Your ref 3/2025/0763
Our ref DC/25/2553
Date 31-OCT-25

Location: Cunliffe House Farm Longsight Road Langho BB6 8AD.

Proposal: Approval of details reserved by condition 9 (foul and surface drainage).

A. Drainage plan of site

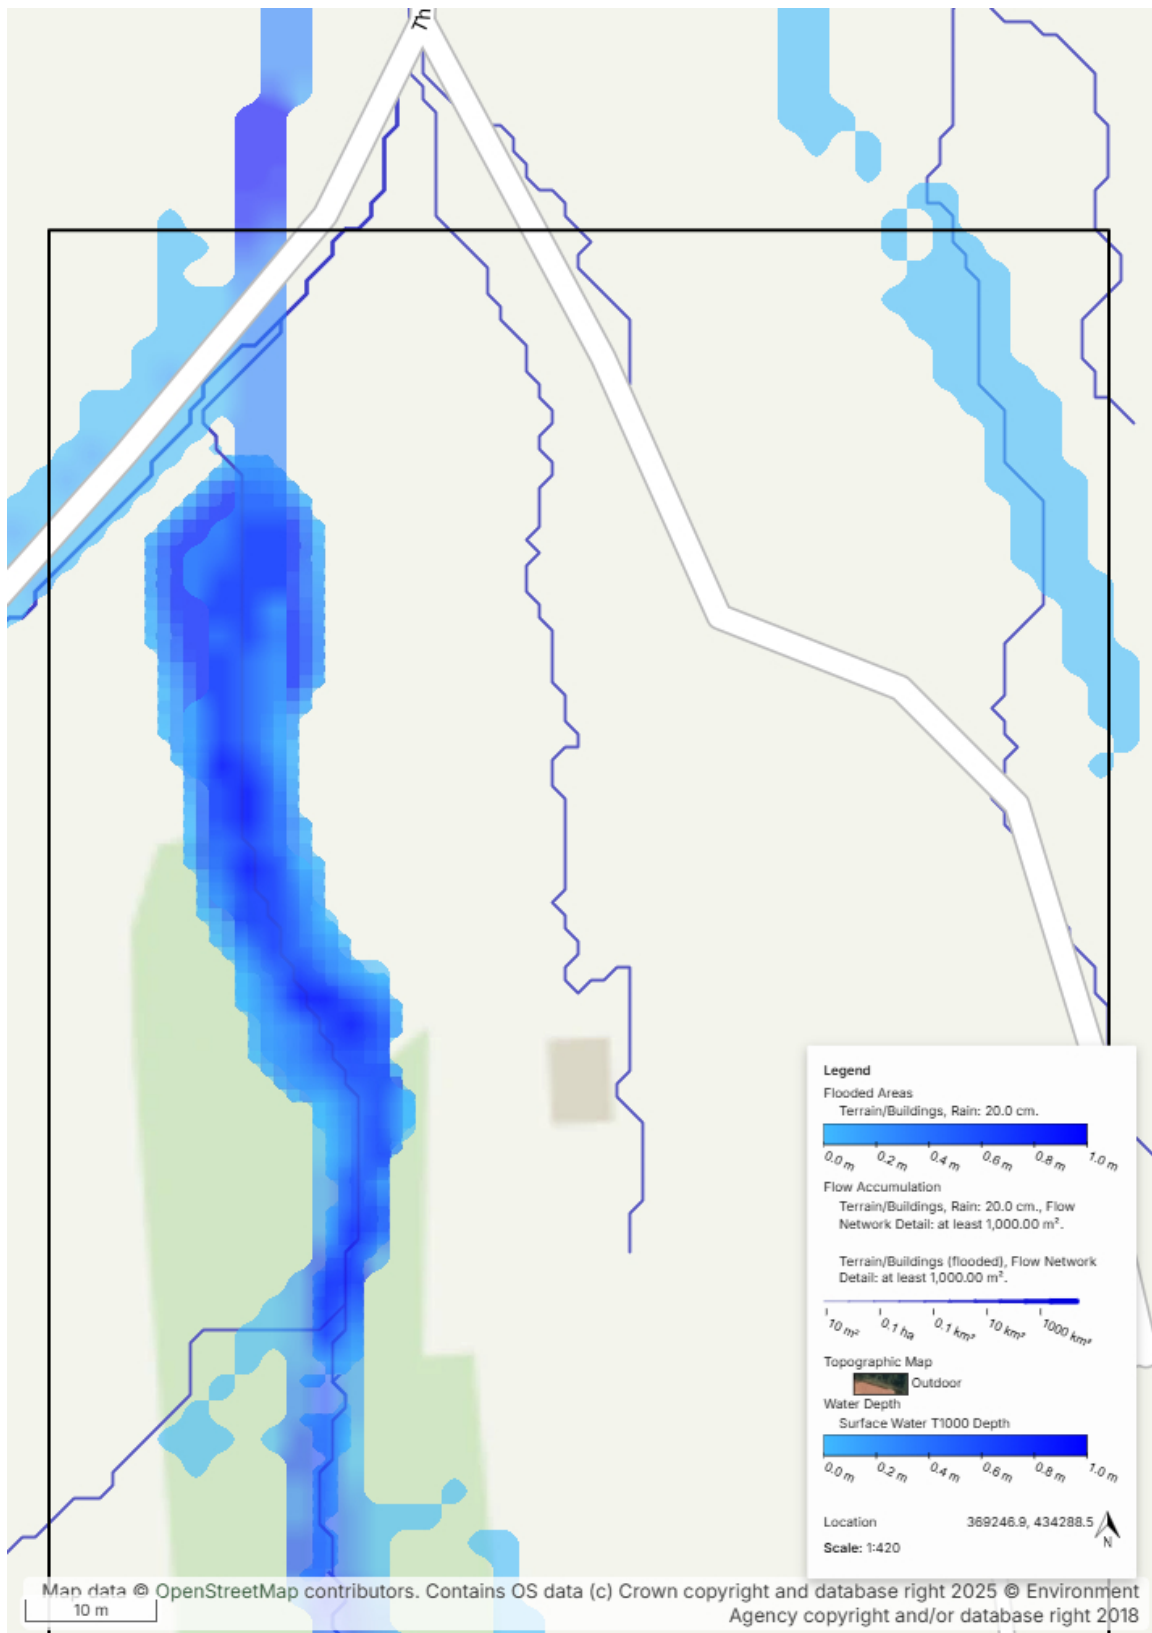
Further to our review of the submitted documents, United Utilities recommends that condition 9 is not discharged. This is because a drainage plan showing the final point of discharge for both foul and surface water has not yet been provided.
